Himley Village, Bicester

Phase 1B, Road Safety Audit - Stage 1 Designer's Response

Date 24 May 2024

Doc ref 27141-HYD-XX-XX-RP-C-0002-P01

TITLE  
PHASE 1B REFUSE & LARGE CAR TRACKING  
SHEET 1 OF 2

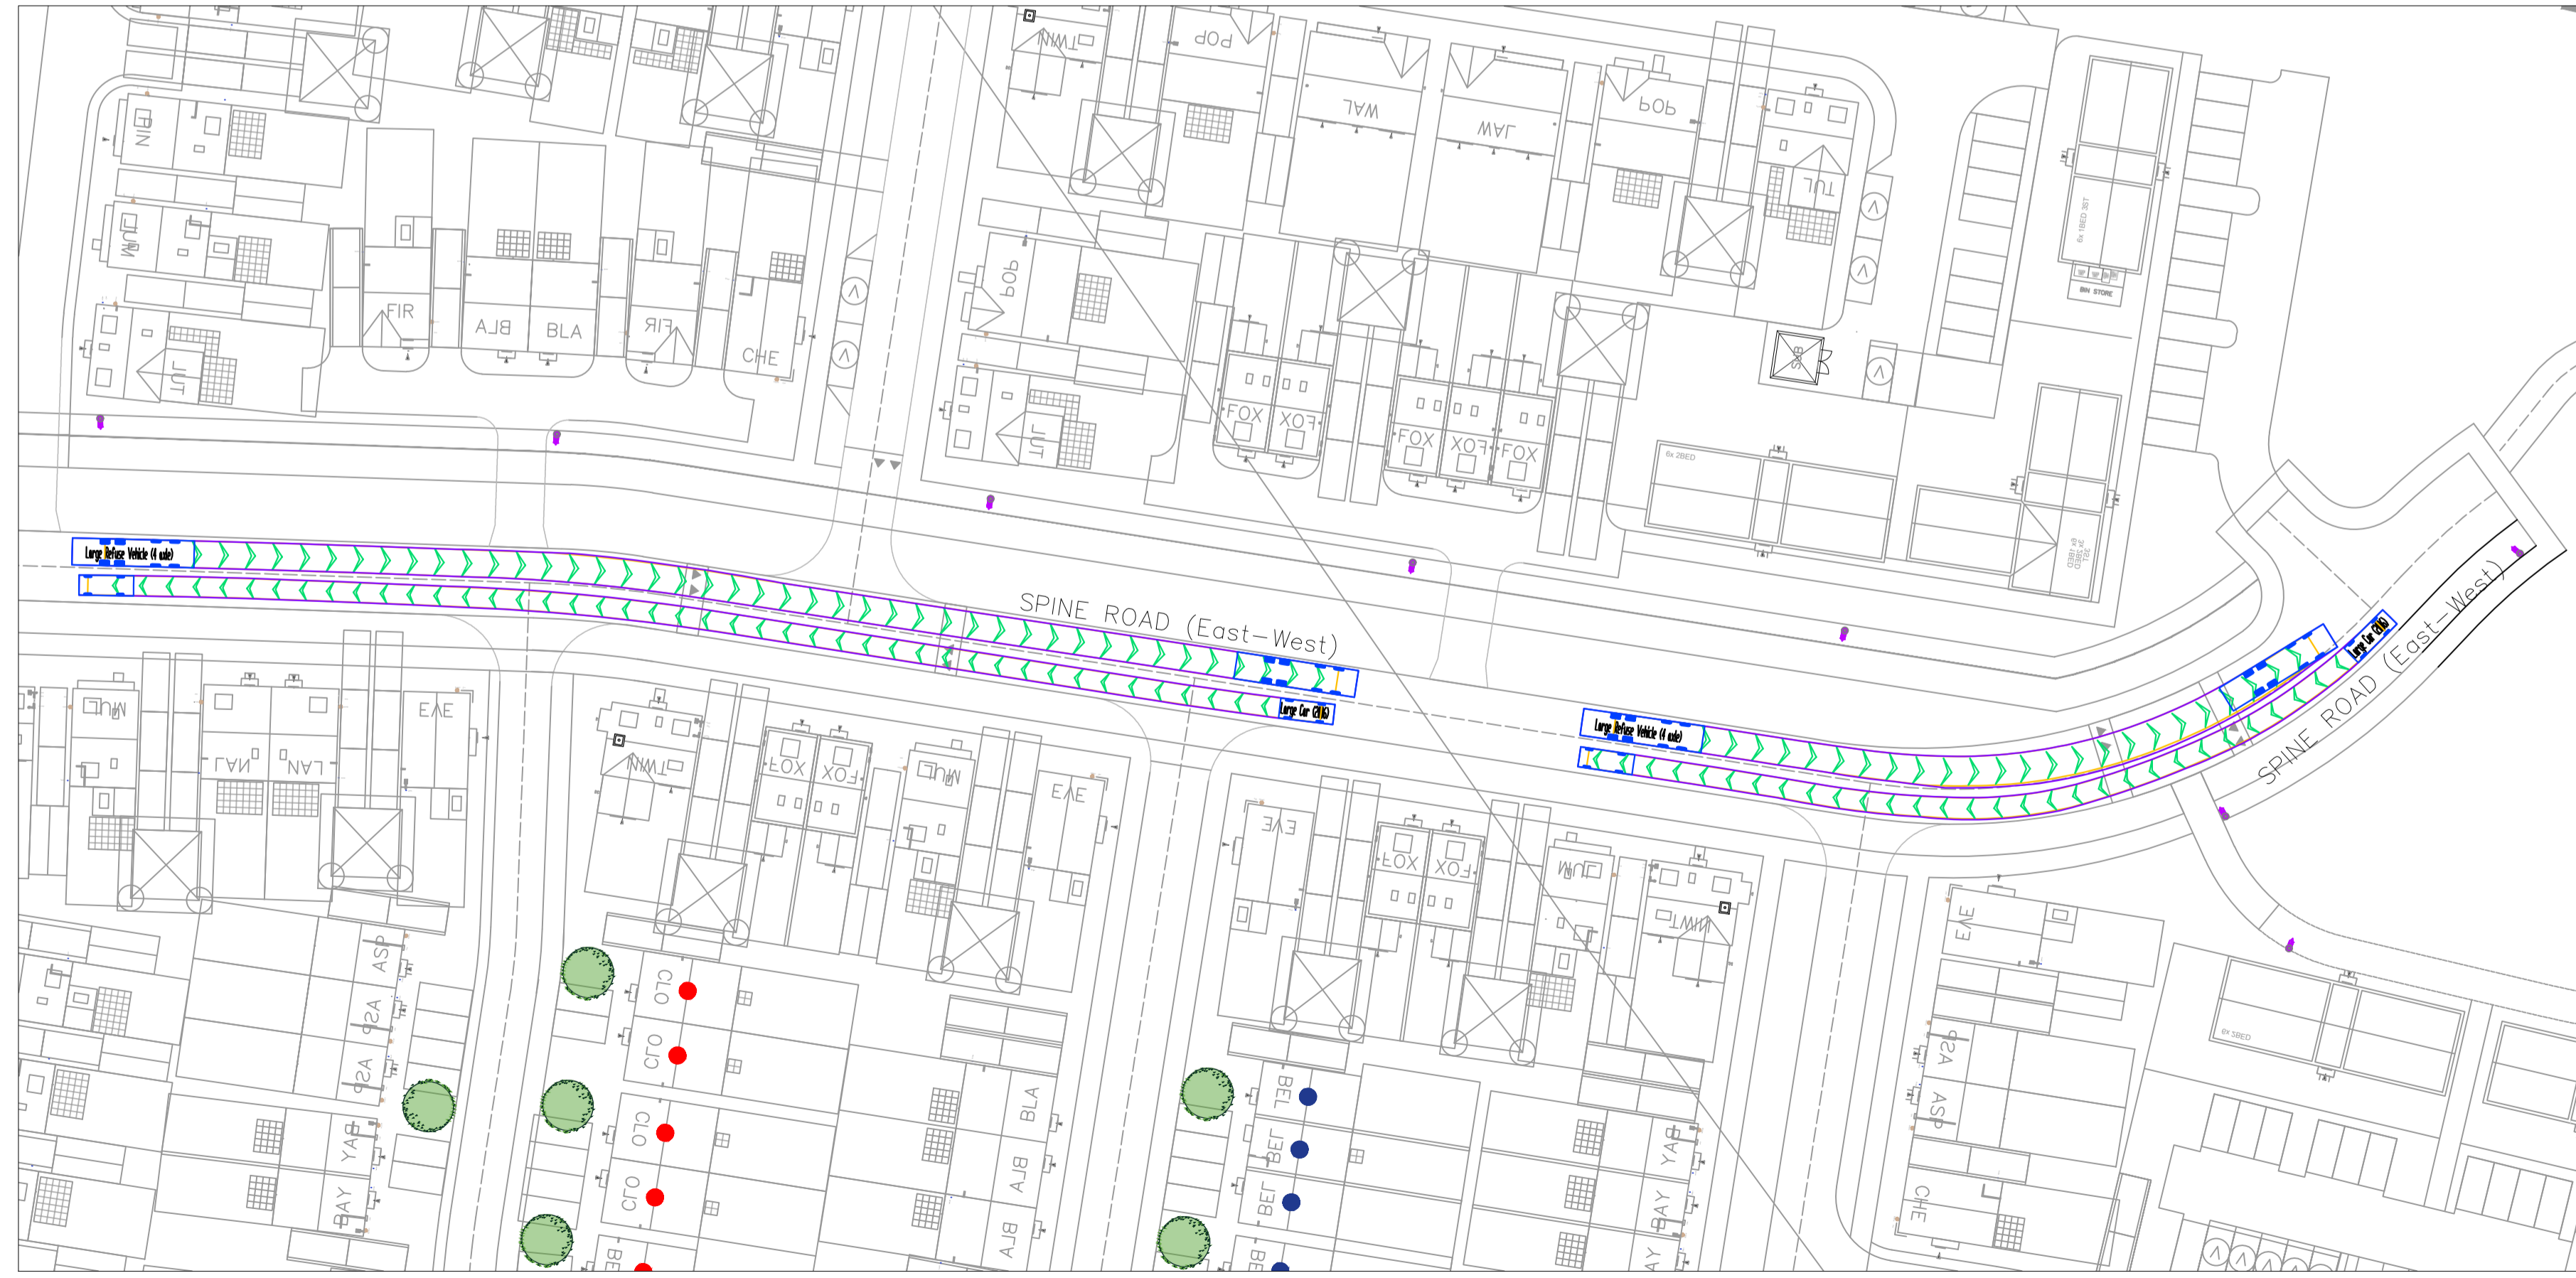
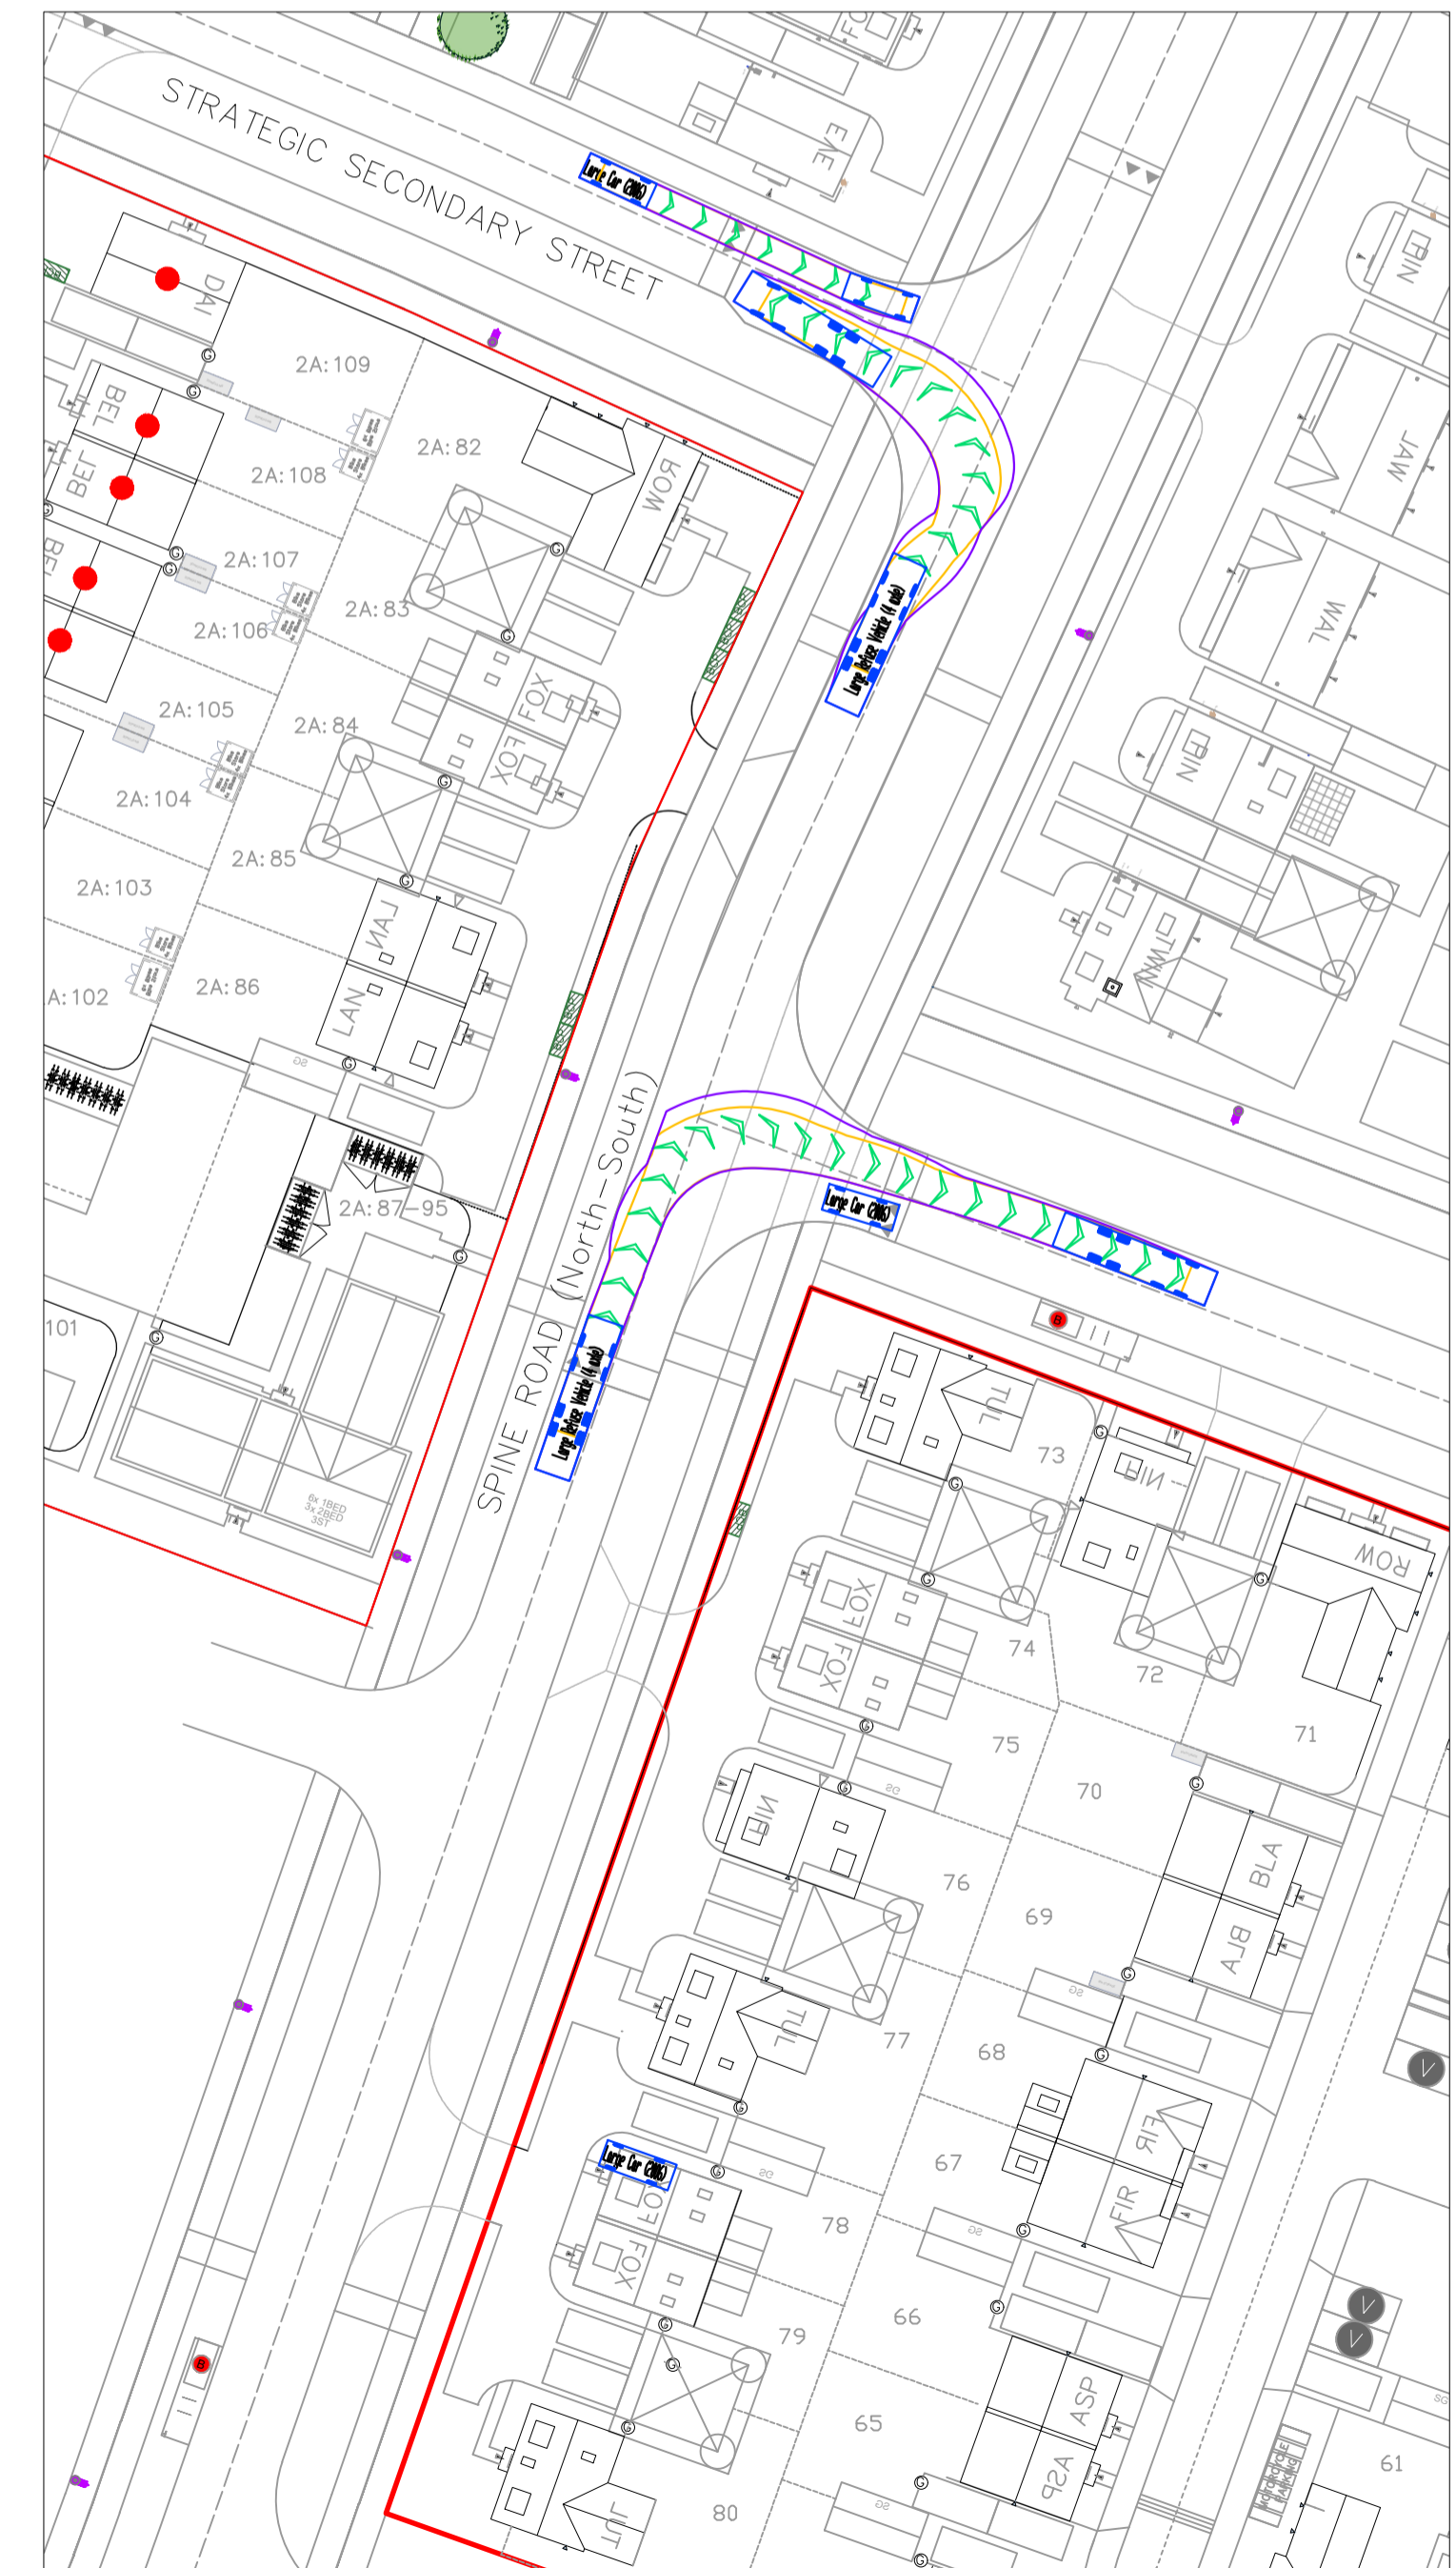
From the vehicle swept path analysis provided as part of the scheme submission, it is evident that larger service/refuse vehicle cannot turn left from the site without encroaching onto the right turn lane. Insufficient carriageway widths to accommodate long wheel based vehicular turning movements may increase the risk of vehicle on vehicle side impact/sideswipe type collisions.

RSA Ref No.	RSA Problem	RSA Recommendation	Design Organisation Response	Overseeing Organisation Response
3.4	Middleton Stoney Road – Vehicular Access Eastern end From the vehicle swept path analysis provided as part of the scheme submission, it is evident that larger service/refuse vehicle cannot turn left from the site without encroaching onto the right turn lane. Insufficient carriageway widths to accommodate long wheel based vehicular turning movements may increase the risk of vehicle on vehicle side impact/sideswipe type collisions.	The Audit Team recommends providing adequate carriageway geometry to ensure that all likely vehicle types to use this junction can carry out turning safely and without obstruction.	DISAGREE: The eastern site access is the secondary access onto a 5.5m road into the site; providing tapers within the area increases the size of the minor junction, which should primarily be used by cars. The only HGVs using the access should be the occasional refuse vehicle. HGVs typically encroach on the adjacent lanes, when exiting minor junctions.
